Your Ref: OWPC17767
Our Ref: FG/202/17/PL 15-12-2017
Please ask for:
Ross Leal

Change of use from restaurant (A3 Restaurant) to takeaway (A5 Hot Food Takeaway),
repositioning of extraction flue, removal of existing rear extensions, erection of rear
extension for 1 No. flat.

104 Ferring Street Ferring

Proposed Roof Plan

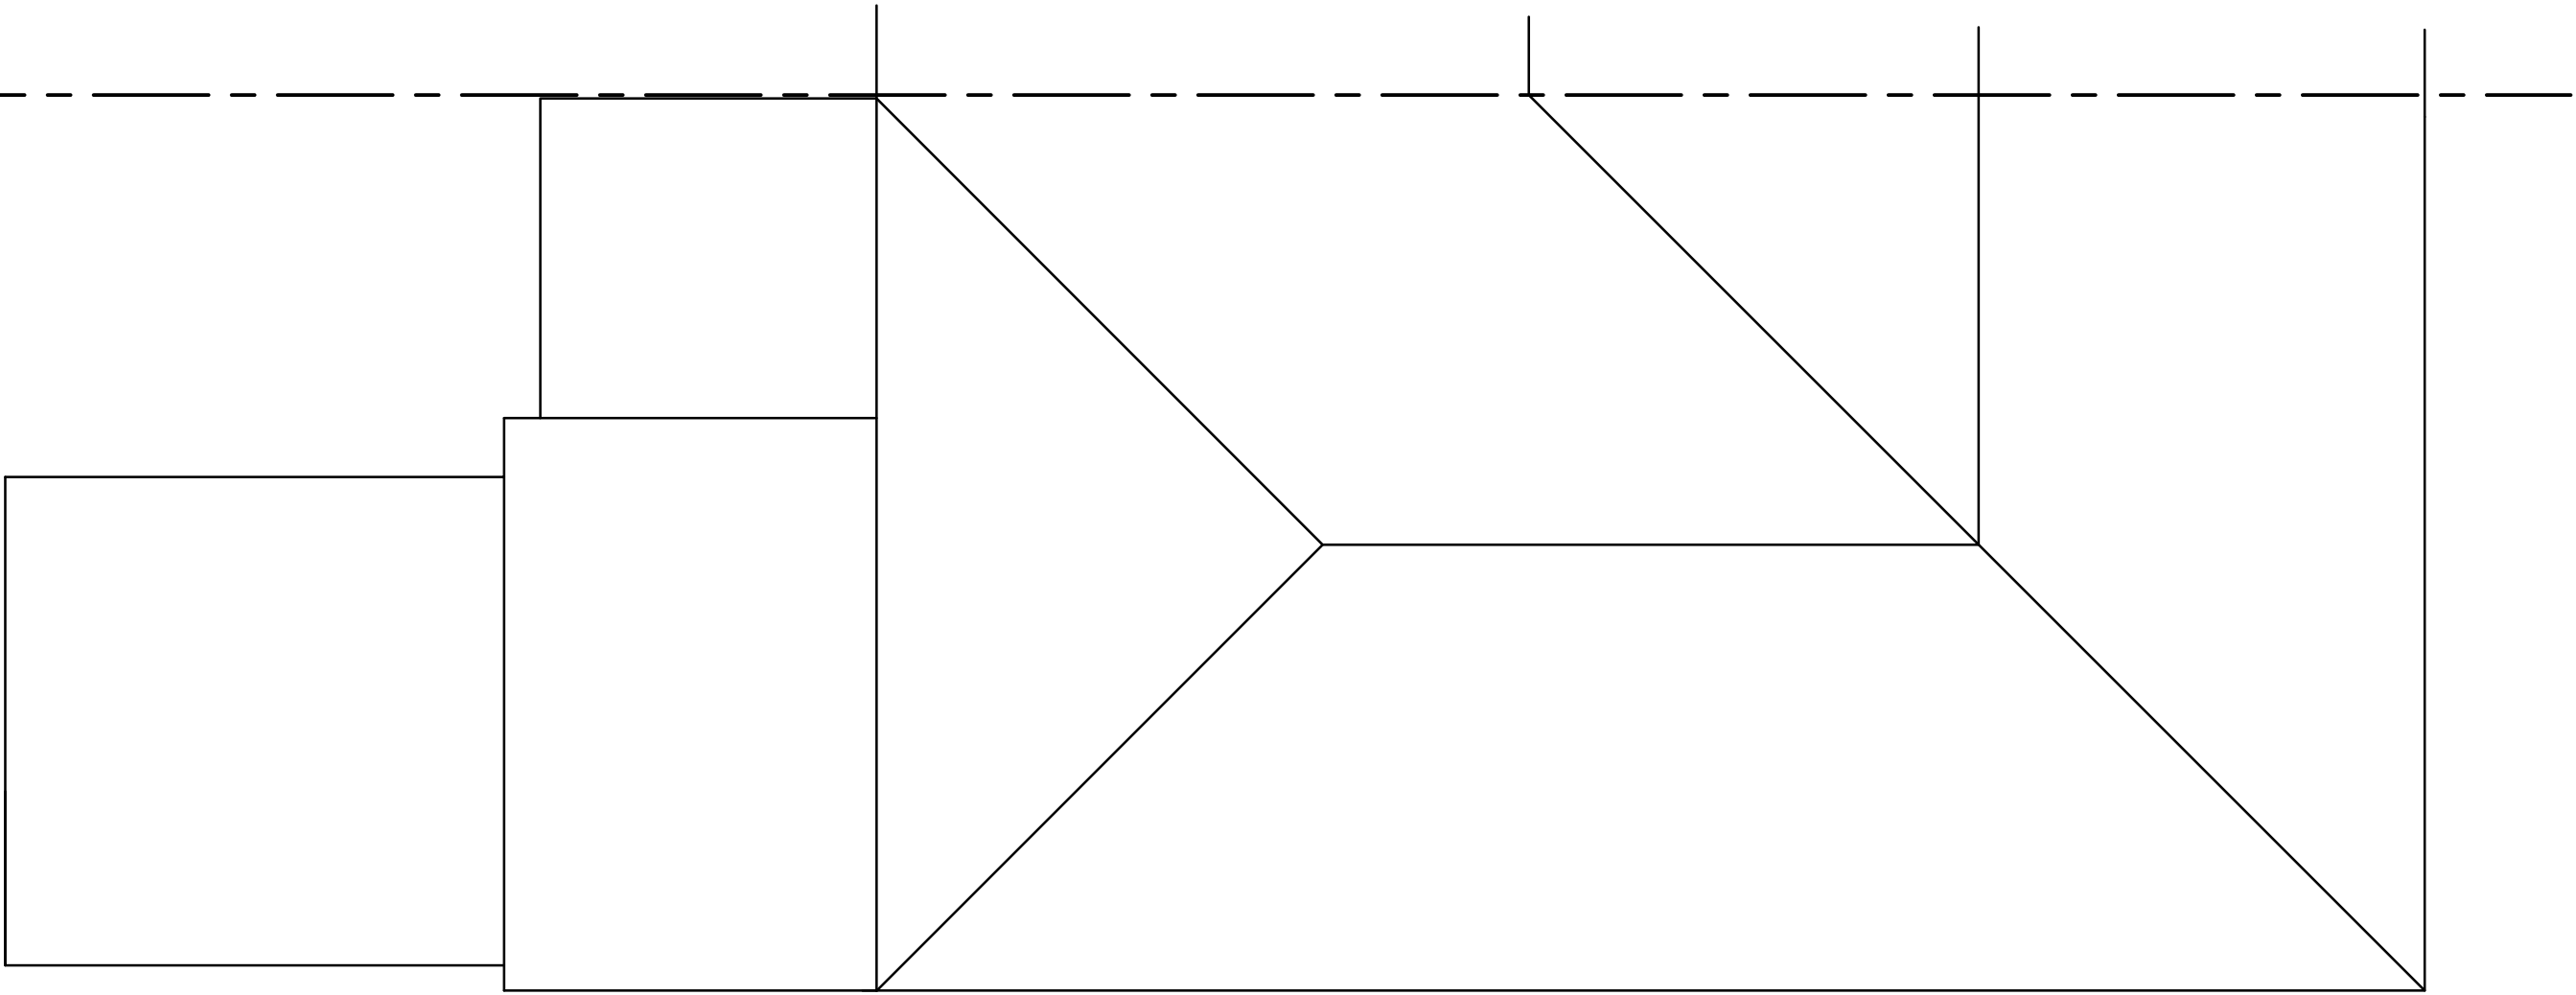
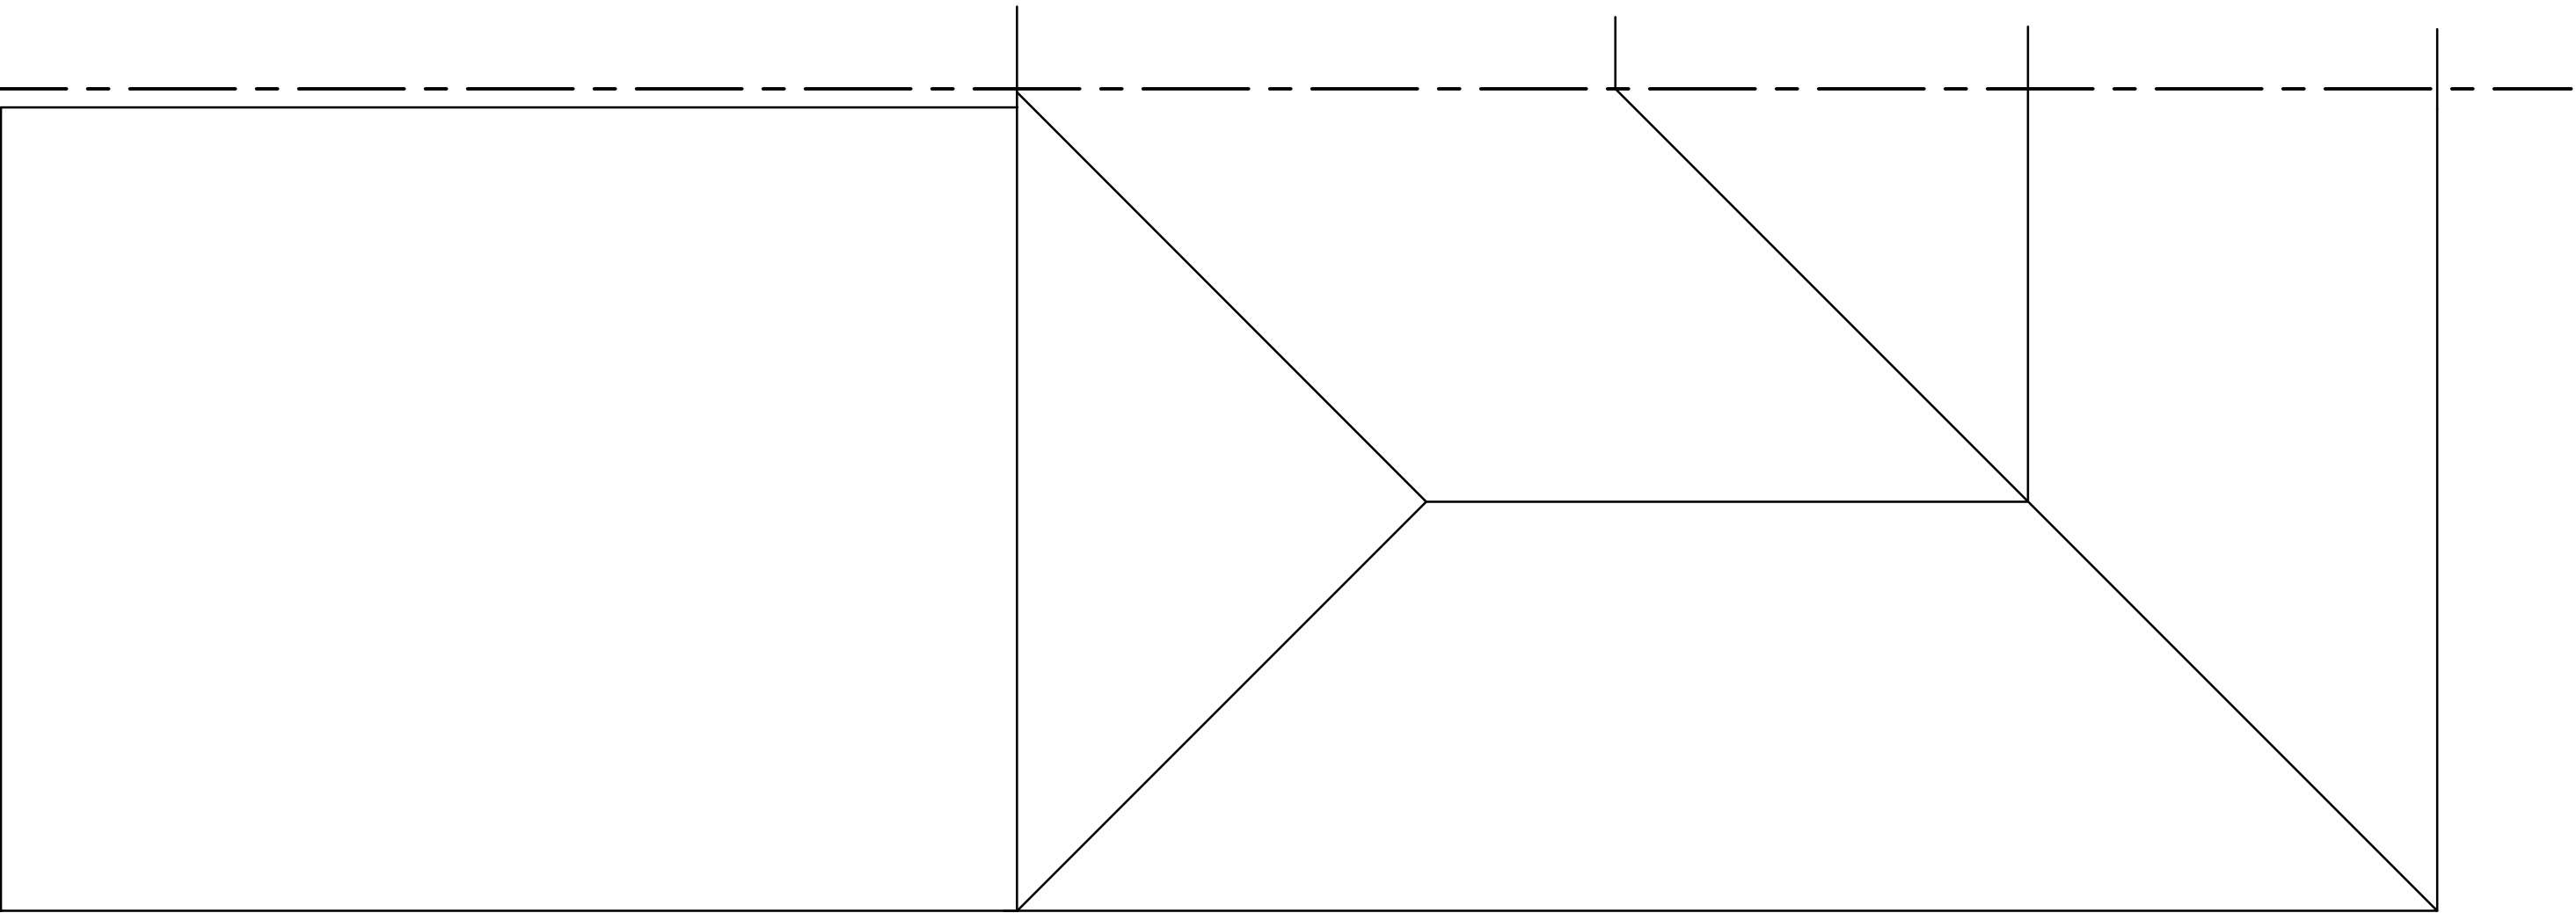
*MY ONLY CONCERN IS THE DIAMETER OF THE PROPOSED NEW EXTRACTION
FLU. THE ORIGINAL FLUE SIZE IS NOT TRUE TO SCALE AND LOCATION ON THE
APPLICATIO*
